From: [Downes, Scott G \(DFW\)](#)
To: [Ian Loveless](#); [Jeremiah Cromie](#)
Cc: [Ed Sewall](#); [Jeremy Johnston](#)
Subject: RE: RU-22-00001 Ski Acres Estates Site Visit/Detailed Mitigation Plans?
Date: Friday, April 15, 2022 4:32:46 PM

MITIGATION SITE PLAN

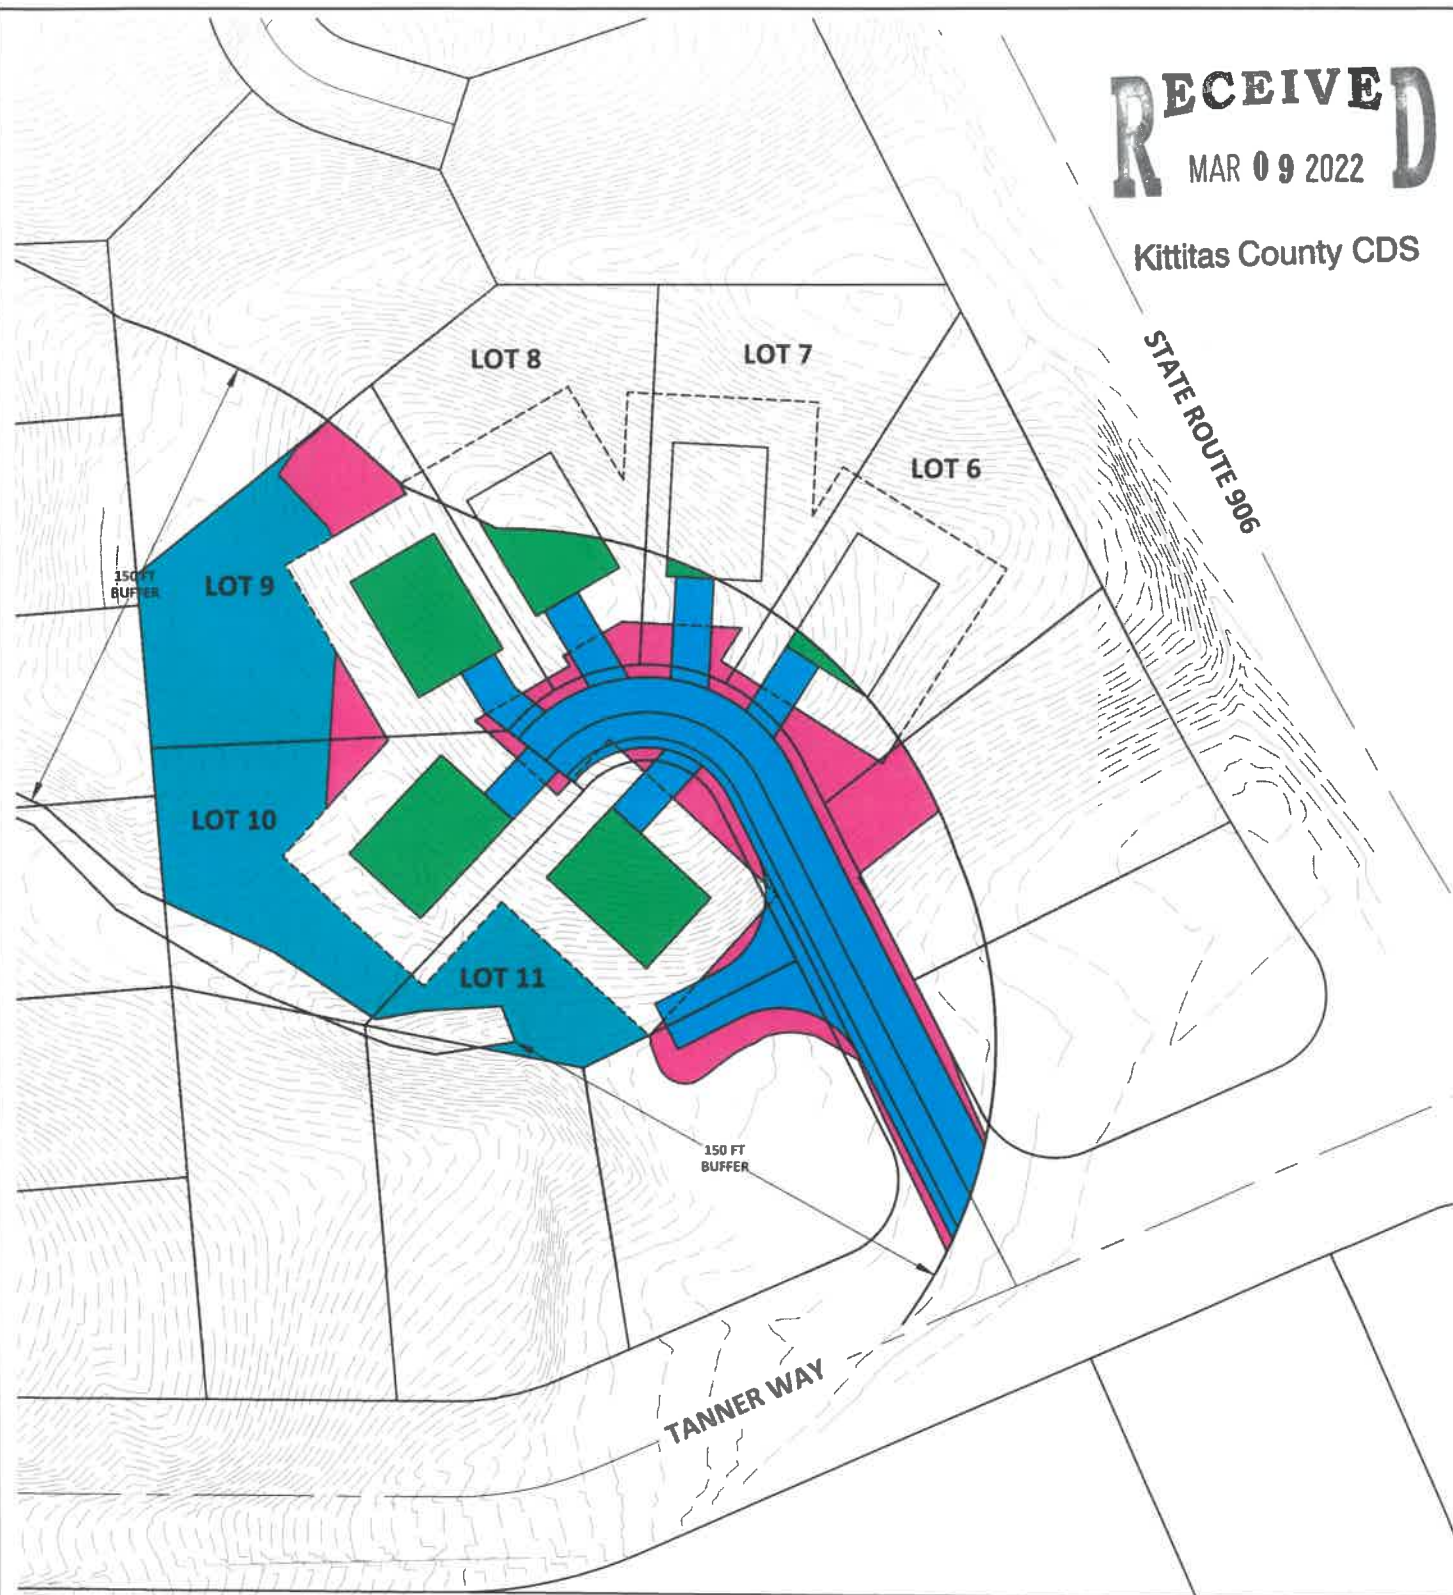
My original condition is I thought we could allow some encroachment, but still staying well away from the creek and needing to leave the trees that were contributing shade and other riparian protection, nutrients, runoff etc.. Its hard to tell the "bold trees from the lighter trees". I'm making the assumption that the stars are retained trees and the circles are removed. Many of these trees are much too close to the stream to having any removal, regardless of what mitigation we are putting back. Seedling trees and downed logs function as some habitat, but not nearly what overstory trees do.

I'm happy to look on site, right now the morning of May 9th would be best. If not, that May 17 or 19. I think there needs to be a minimum distance of nothing removed, say 50' and then from 50-150' any trees that are overstory and contributing shade need to be retained and other trees could be offset with riparian enhancements in this blue area.

Maybe I'm still not reading the sheet right and we can look further in May, but a couple of home sites appear to be near 50' from the stream, so how are we going to ensure the homeowner will keep these enhancements in when they are right in their backyard?

Thank you for the follow up questions on the Ski Acres RUE application. We apologize for the lack of detail in our submitted mitigation plan, but the timing (given existing snow on site) made it difficult to include granular planting detail for the buffer improvement areas. Ed is planning to layer in that detail when the snow melts out enough on site (probably mid May). For now, I am attaching a tree survey we had done after Scott's initial site visit. The bolded trees would be retained and the lighter trees would be removed as part of our grading work. From this, you can get a good sense of where our buffer improvement work would be concentrated (southern portion of lots 10 & 11, where there are currently no trees in the stream buffer) - in addition to other areas where it makes sense.
